Marine
Management
Organisation

MMO Reference: DCO/2018/00015
Planning Inspectorate Reference: EN010092

APPLICATION BY THURROCK POWER LIMITED (THE APPLICANT) FOR AN ORDER GRANTING DEVELOPMENT CONSENT FOR THE THURROCK FLEXIBLE GENERATION PLANT

Deadline 2 Response

**Thurrock Flexible Generation Plant
 Deemed marine licence coordinates plan**

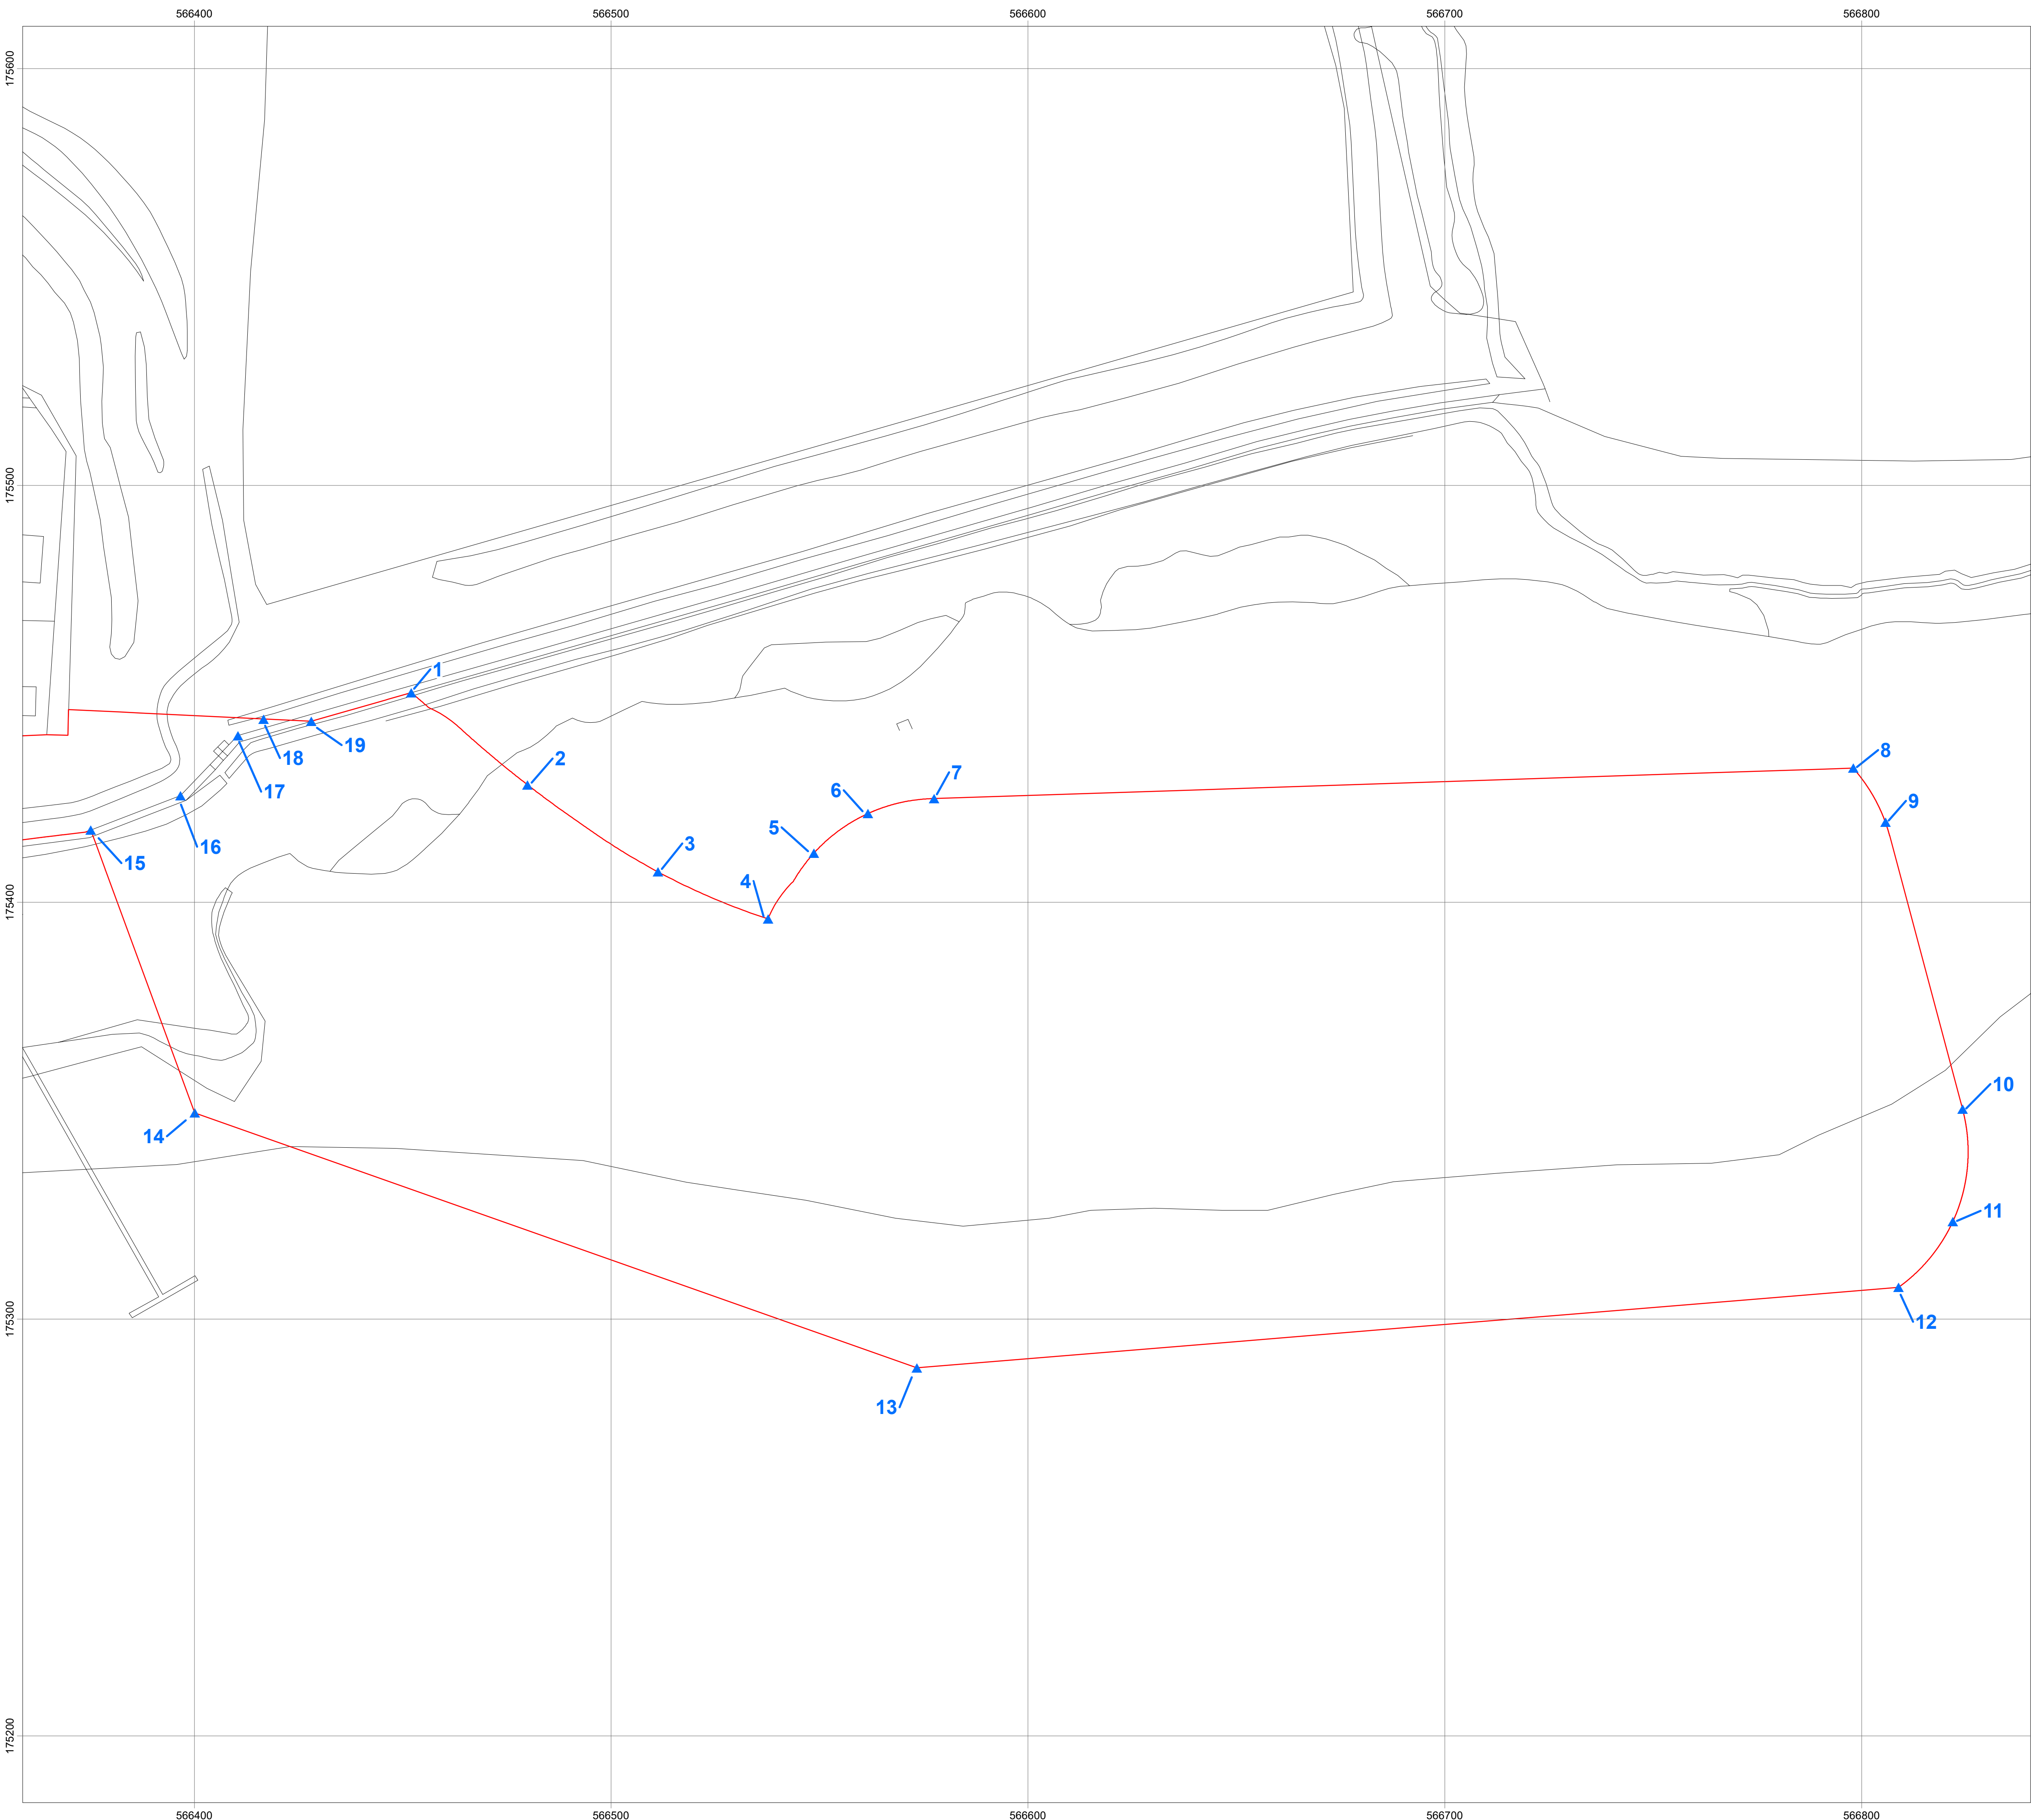
5.1.3. With regard to question 1.10.14 – The MMO would like to highlight the need to update the coordinates in the DML to reflect the most up-to-date boundary following the removal of Work no.9 (Part 1, table 2).
